# Think Again. Winthorpe Action Group

## Examination of National Highways' response to the Relevant Representations

DRAWING TITLE  
 Figure 13.2  
 River Waterbody Catchments

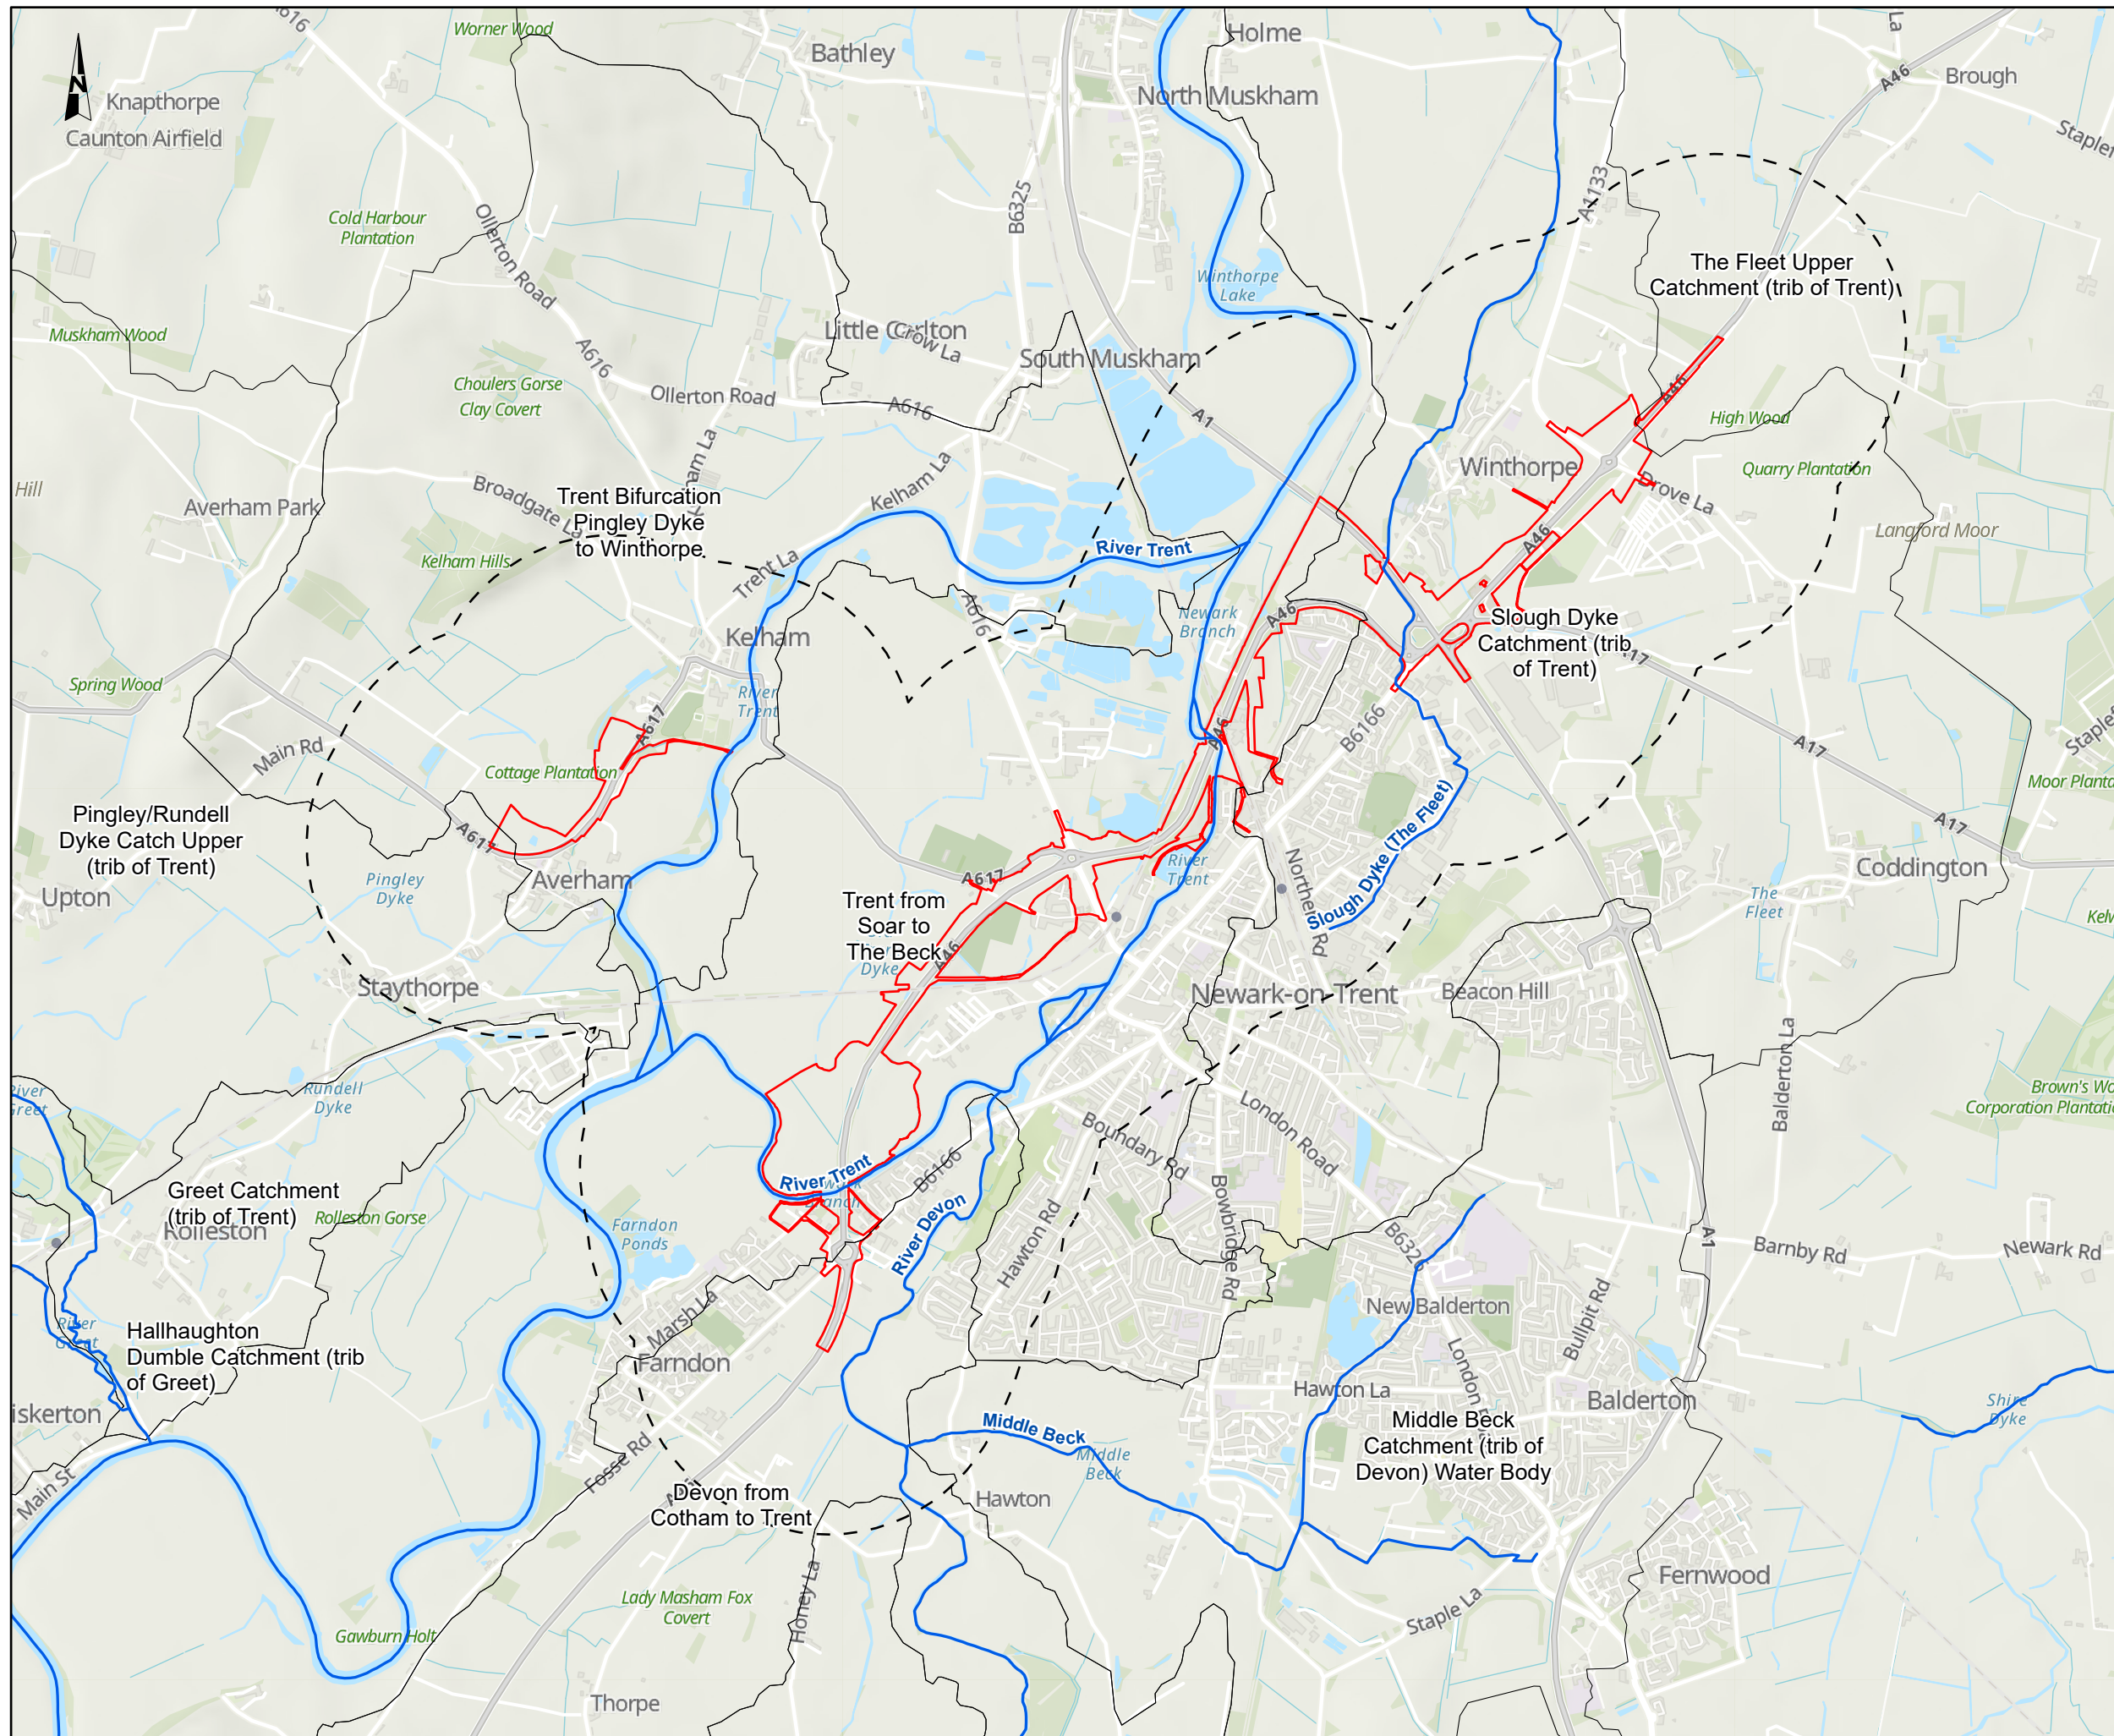
The catchment of the Fleet Upper (tributary of Trent) (GB104028053430) waterbody does overlap with the study area, but the watercourse itself is located outside the study area (as shown Figure 13.2 (River Waterbody Catchment) of the Environmental Statement [APP-113]). Therefore, the WFD waterbody was screened-out as it was deemed to not be hydrologically linked to the Scheme, and the Slough Dyke WFD catchment was assessed in more detail.

As Figure 3, taken from the Environment Agency Catchment Data Explorer shows, this water body is NOT the Fleet that flows through Winthorpe and thus to 'Screen Out' ours on the basis of this mis-identification is not acceptable.
